Recommendation Report for Planning Permission for Works or Extension to a Dwelling

REF NO: FP/261/21/HH

LOCATION: 16 Normans Drive
Felpham
PO22 8LW

PROPOSAL: Single storey side/rear extension and conversion of garage with alterations to fenestration and rendering.

Site	16 Normans Drive, Bognor Regis, West Sussex PO22 8LW	Date	10.11.2021
		Sheet	21-1867 D04 Rev 1
		Job	New Extension
		Scale	As Shown@A1
		Title	As Shown

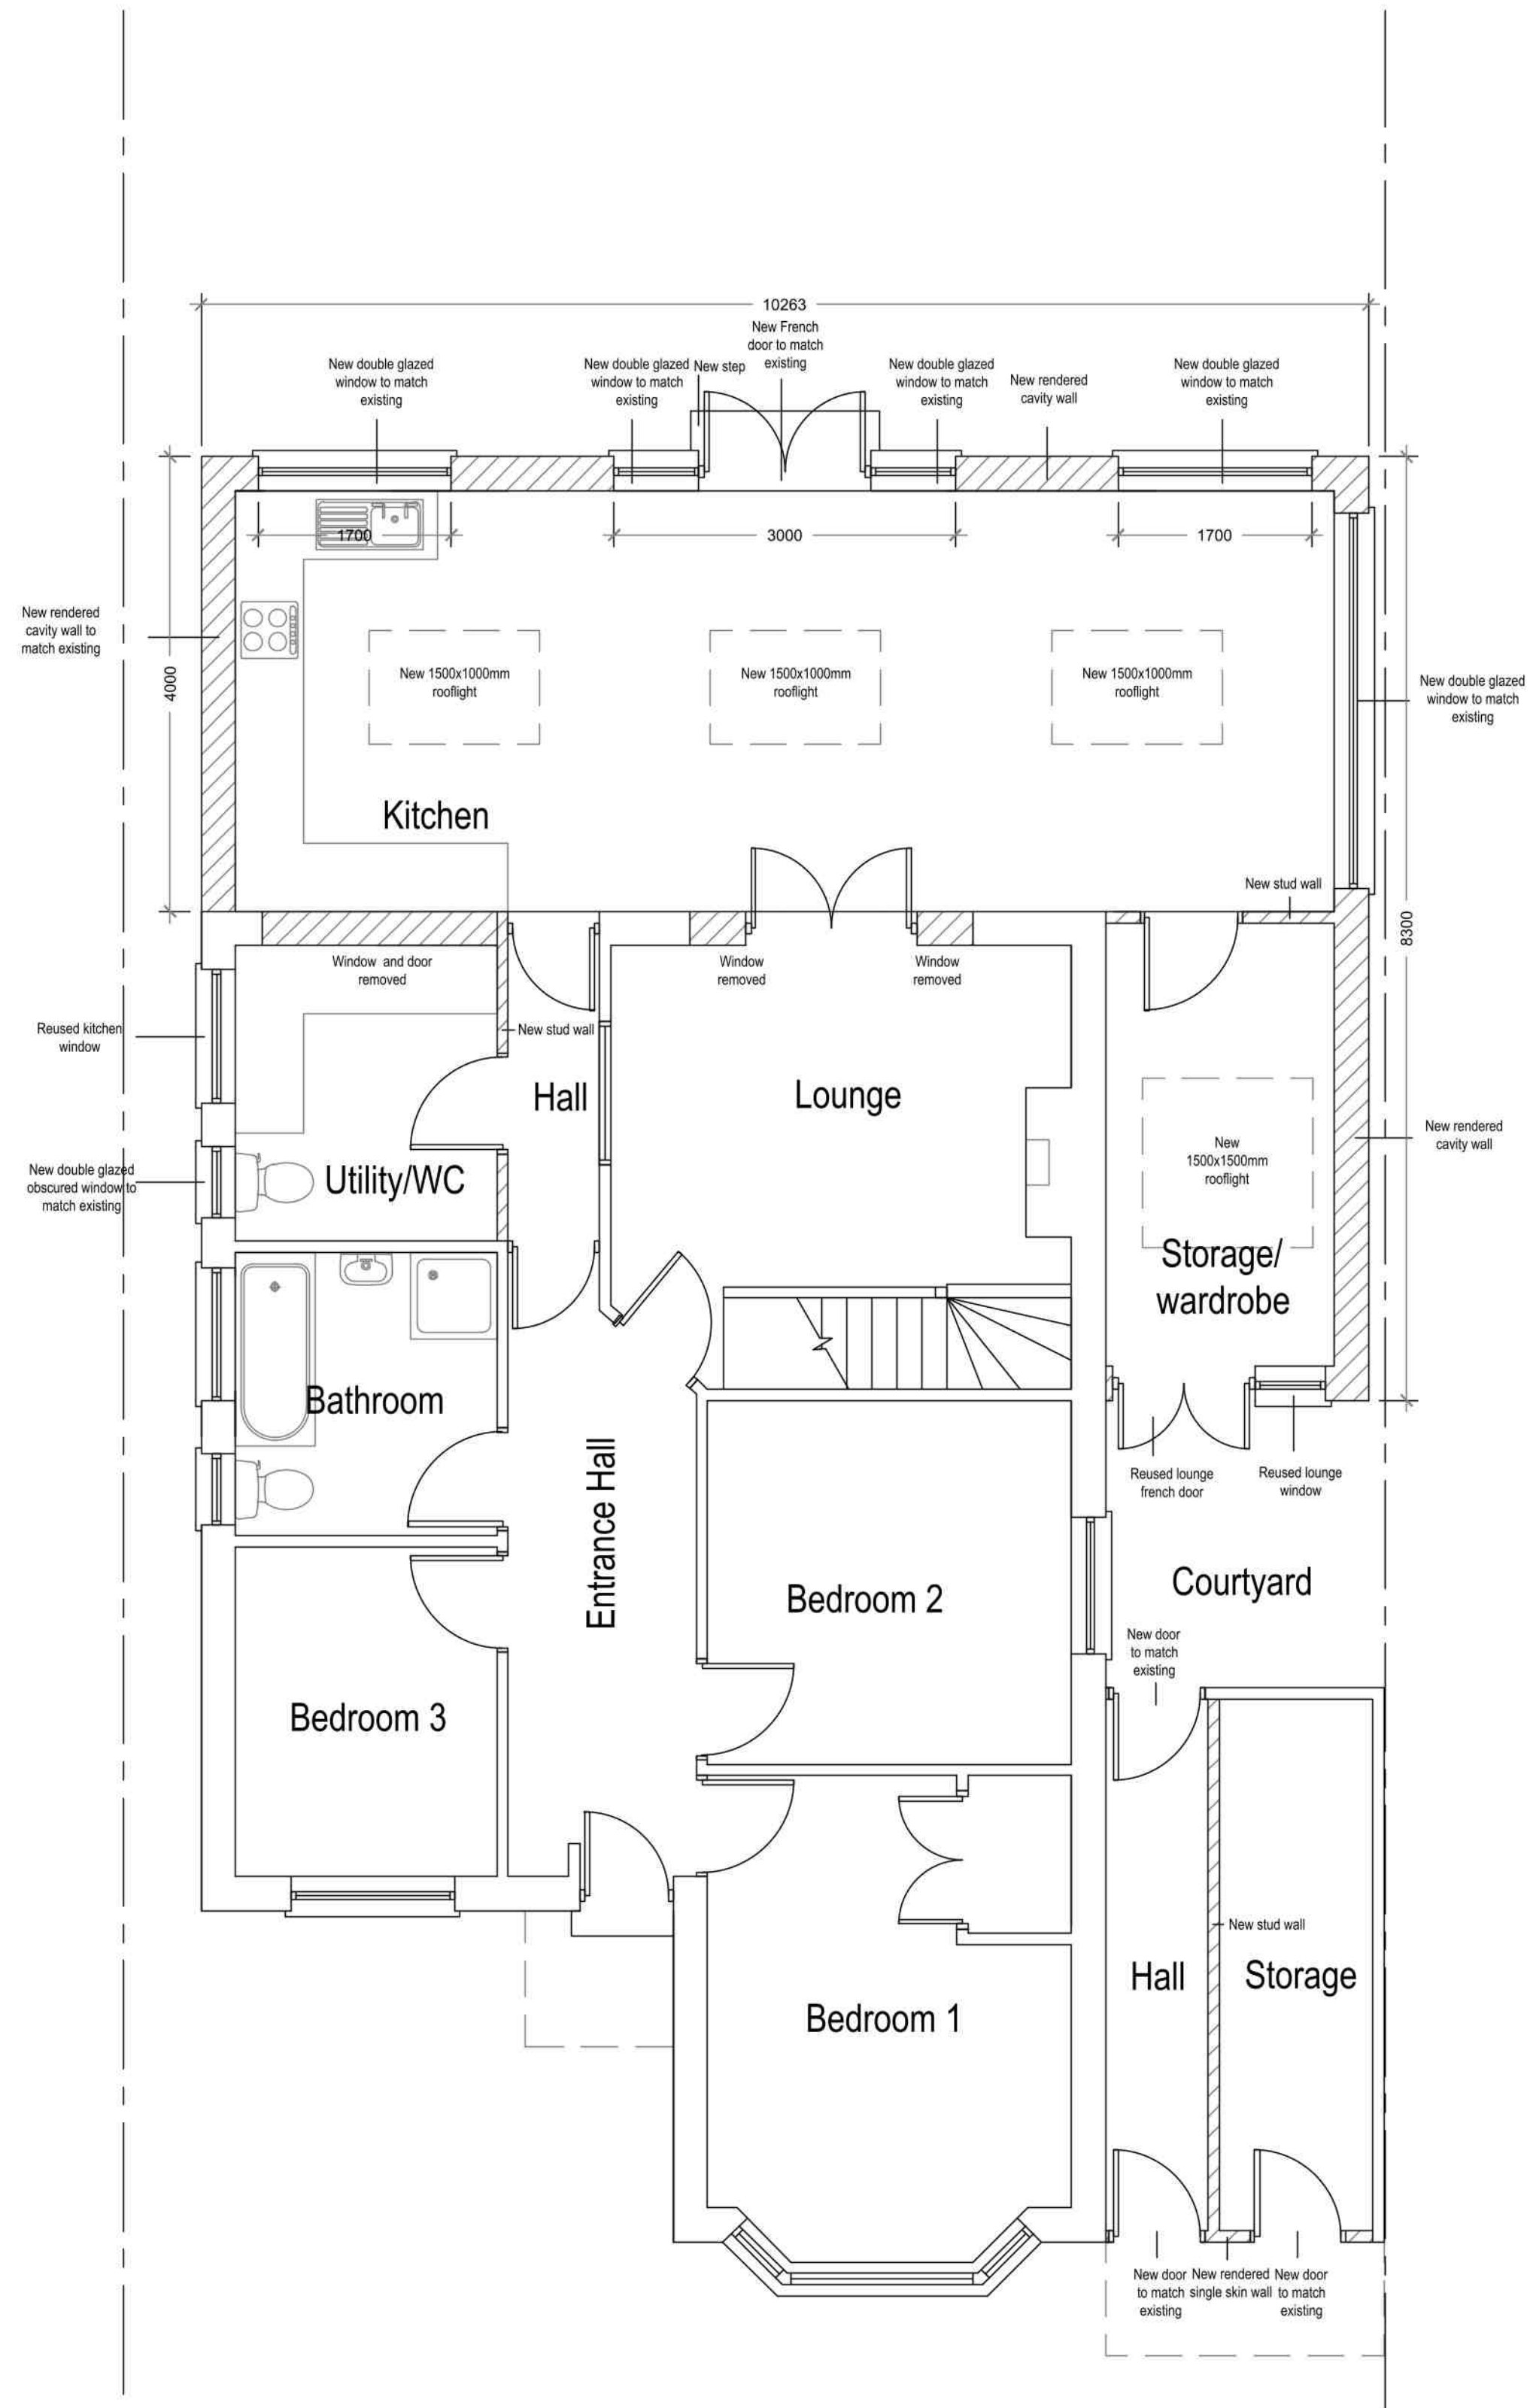
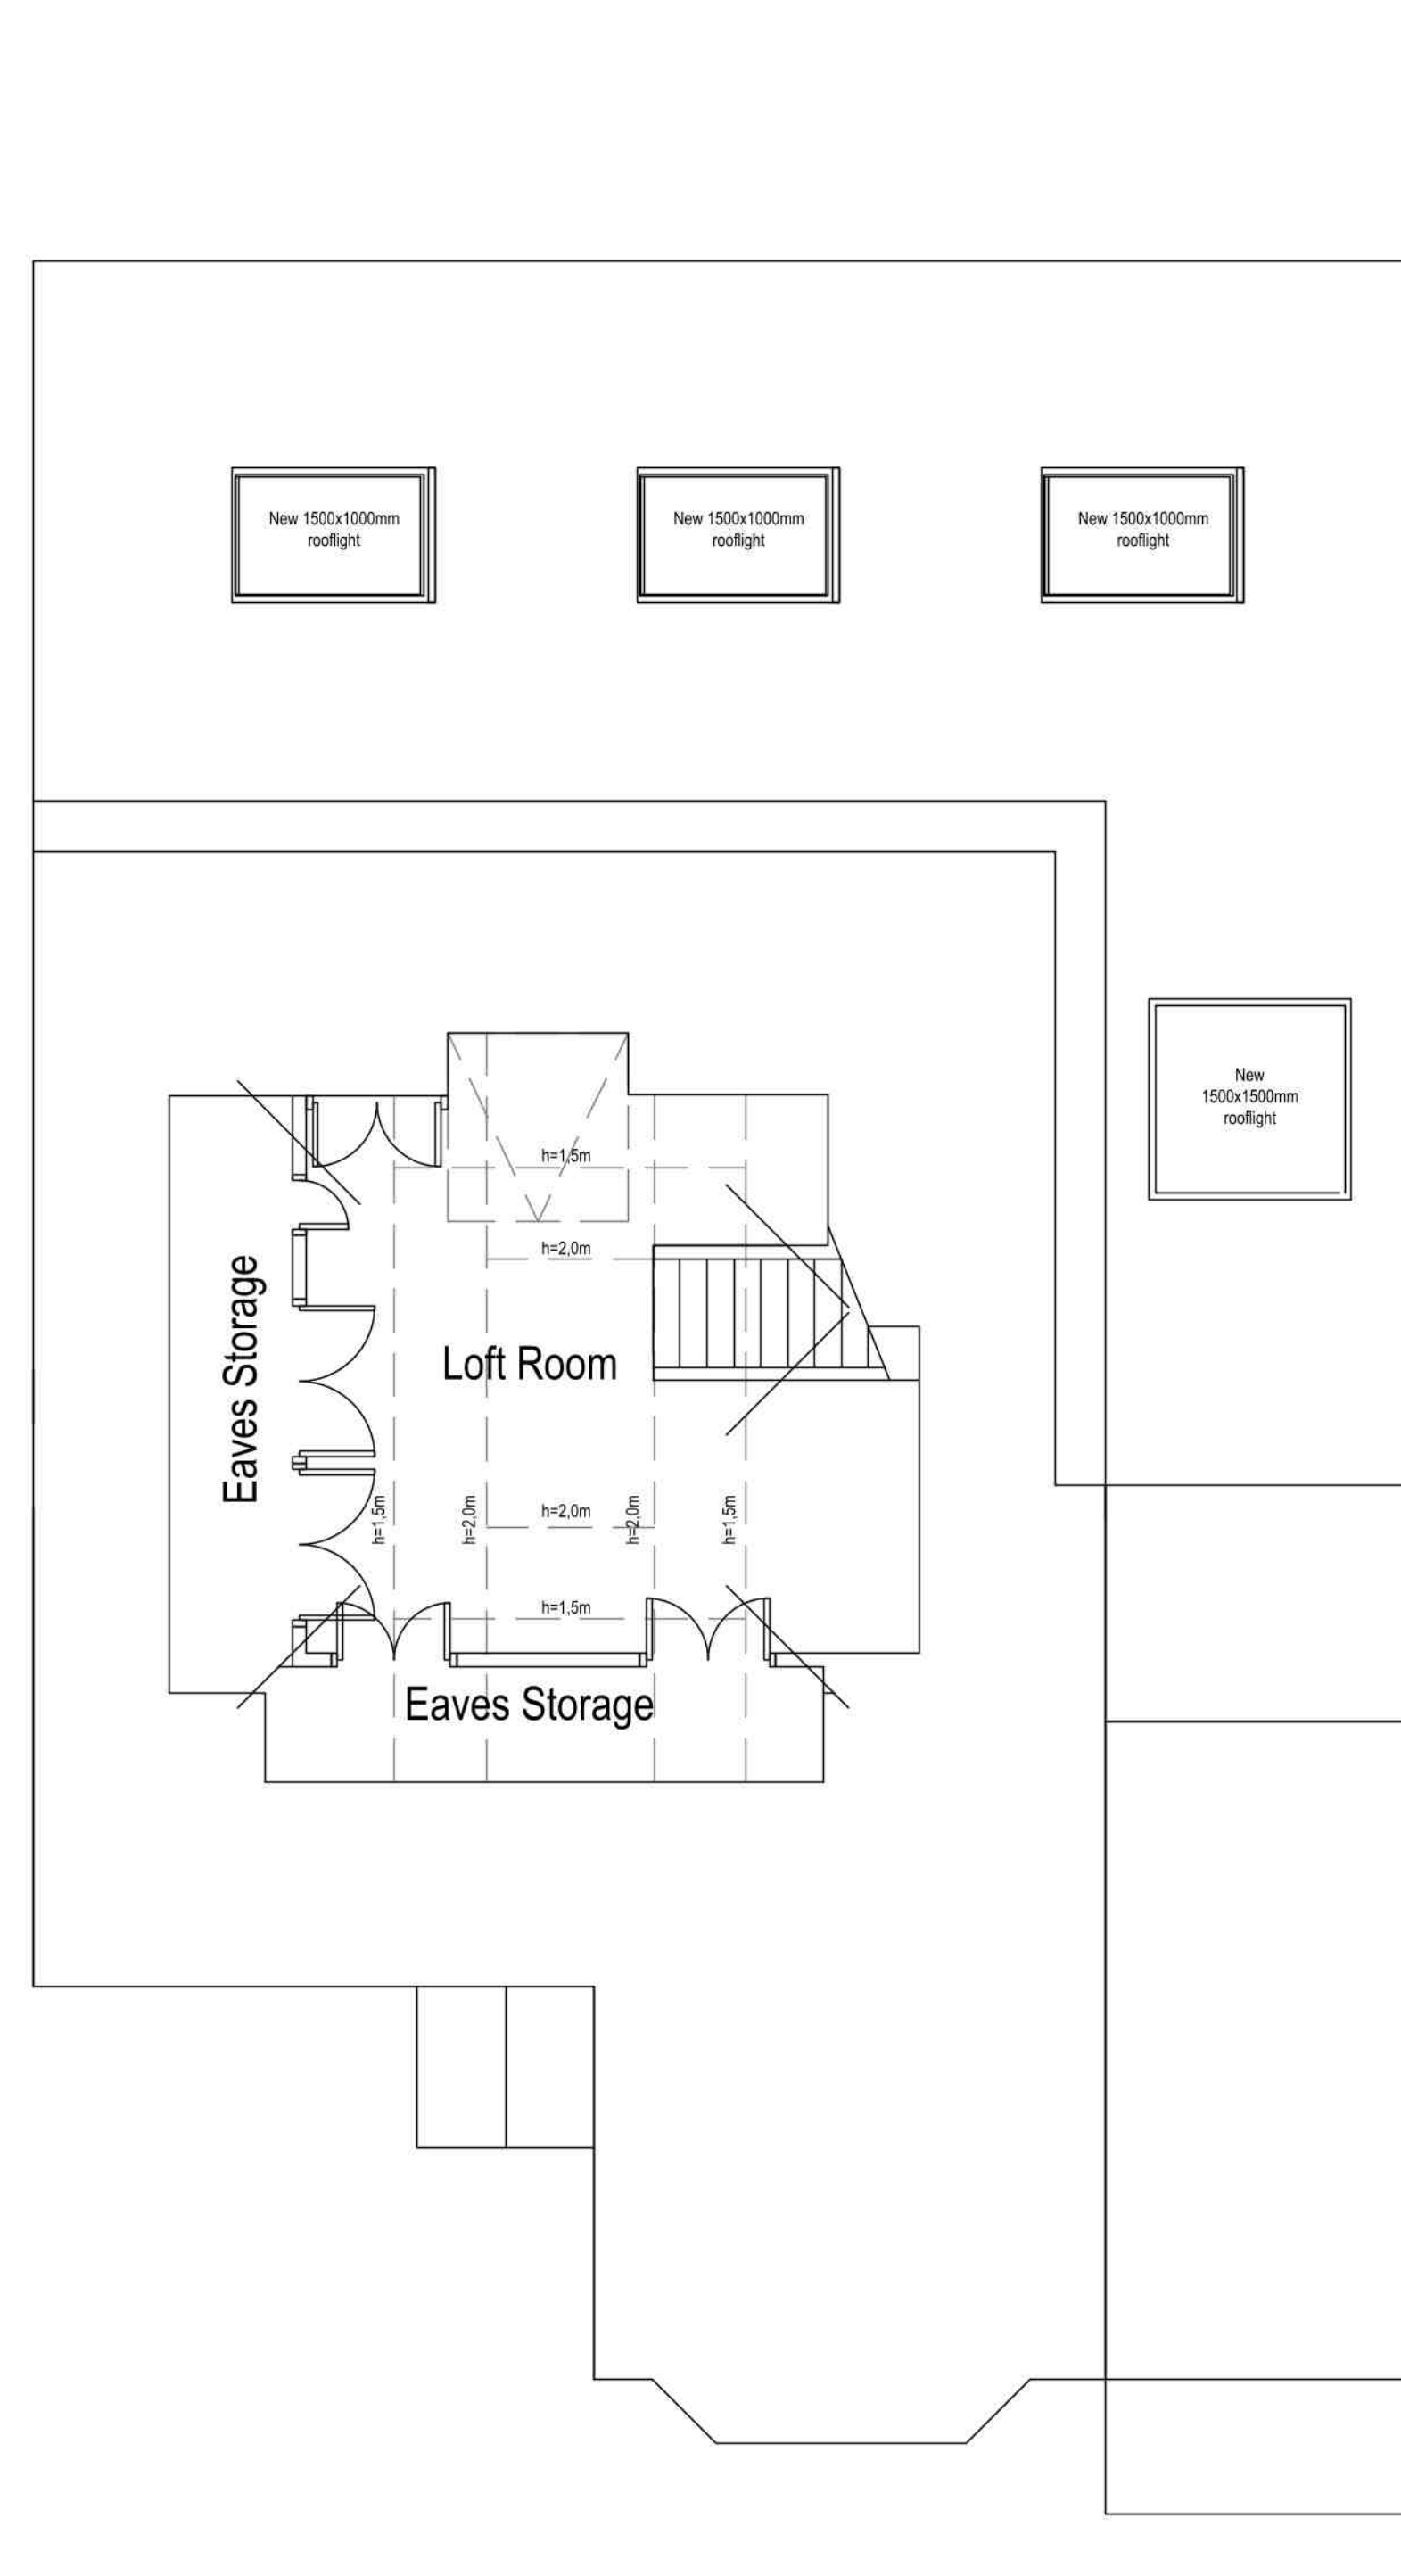
The dwelling is a bungalow and has an attached garage and store to the south side elevation. These will be removed and rebuilt with the garage being converted into habitable use providing a hallway and storage area. To the rear is a conservatory which will be replaced with an extension which will run along the full rear and join with the side addition to the southern elevation.

The garage to the front side will be converted to form a hallway/storage area. It currently meets with the boundary to the south and the length and height will remain the same as existing except the garage door will be replaced with 2 entrance doors.

The rear extension will have a depth of 4m and run along the full rear elevation joining with the addition to the south. This does add some bulk to the dwelling although retains 15m to the rear boundary.
